Town & Country Planning Act 1990 (as amended)
Town & country Planning (Development Management Procedure) (England) Order 2015

Single storey rear extension.

5 Sark Gardens Ferring

Thank you for your internet representation made on 8th November 2017 which has been recorded as '**an objection**' with the comments as follows:

PROPOSED ELEVATIONS 1:100@A3

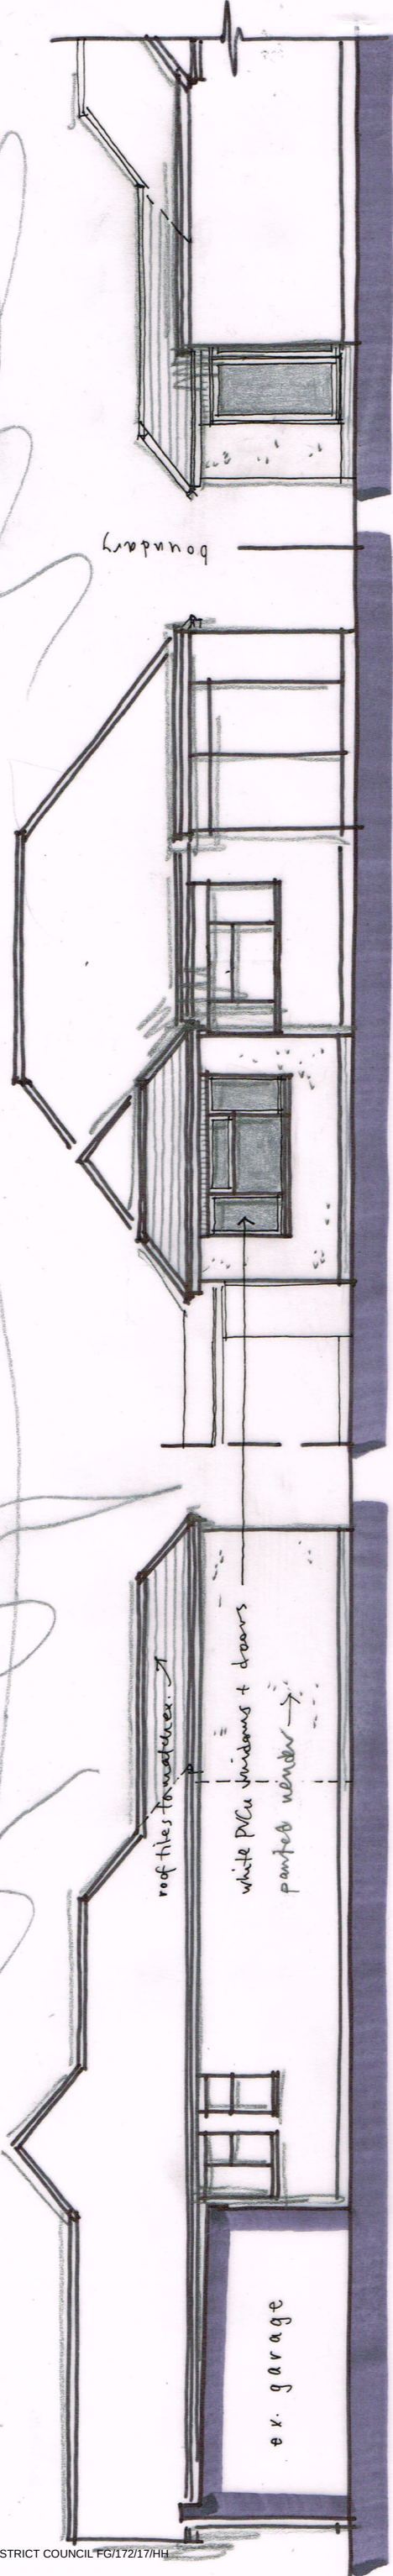
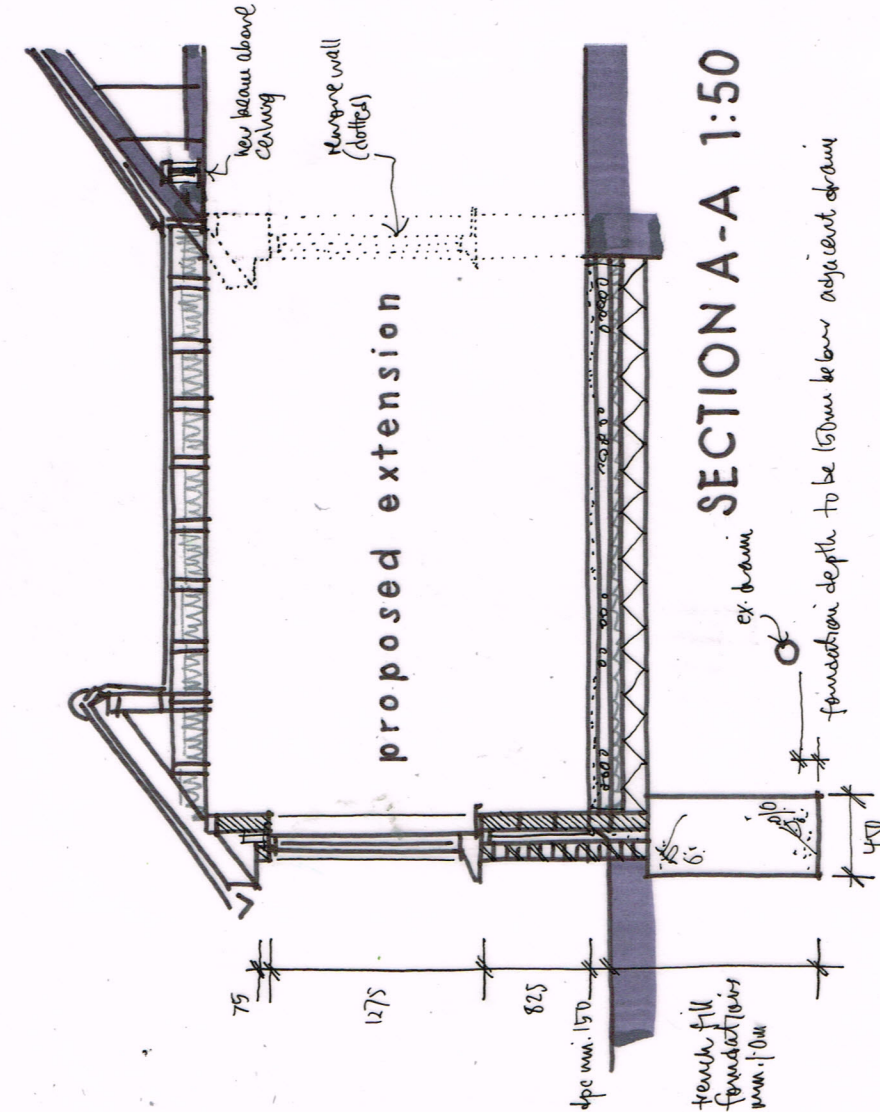
The extension is not in brick and should be to reflect no change to existing and match the adjoining property.

Roof tiles should match the existing.

GROUND FLOOR PLAN 1:50

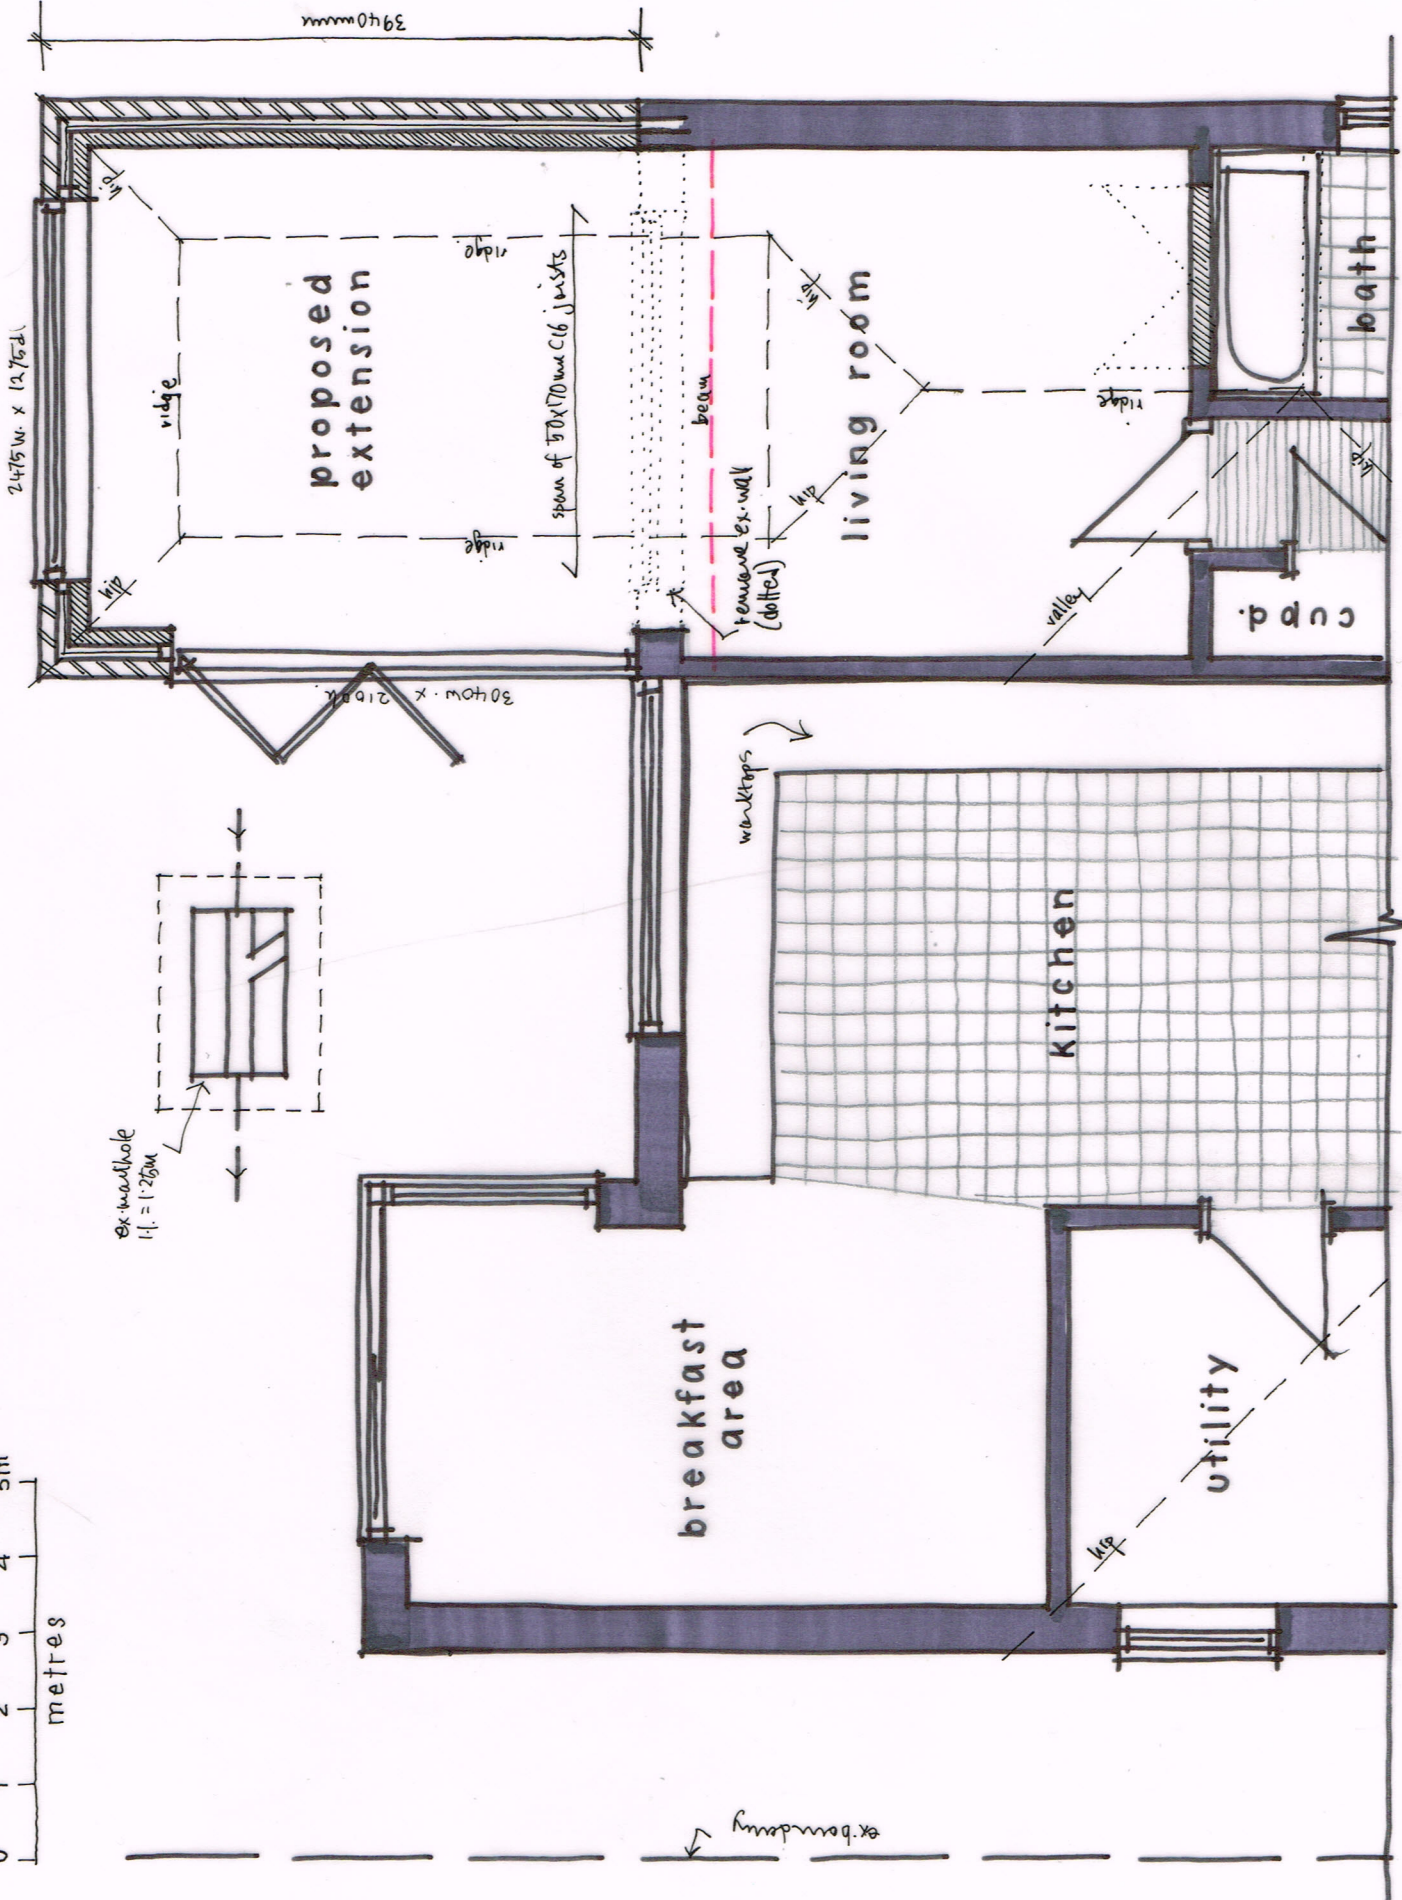
The application only appears to show the ground floor without any bedrooms or revised access to rooms in the roof. The extension is built over the existing drains and therefore needs to comply with Southern Water regulations as other properties use the shared drains along that run. Properties in the location do suffer from blockages therefore full access is essential.

The floor plan must show the layout to include bedrooms and stairs to bedrooms clearly that is the intention to increase the occupancy which I would object to in any case as the intention to make a 2 bed bungalow much bigger by stealth.
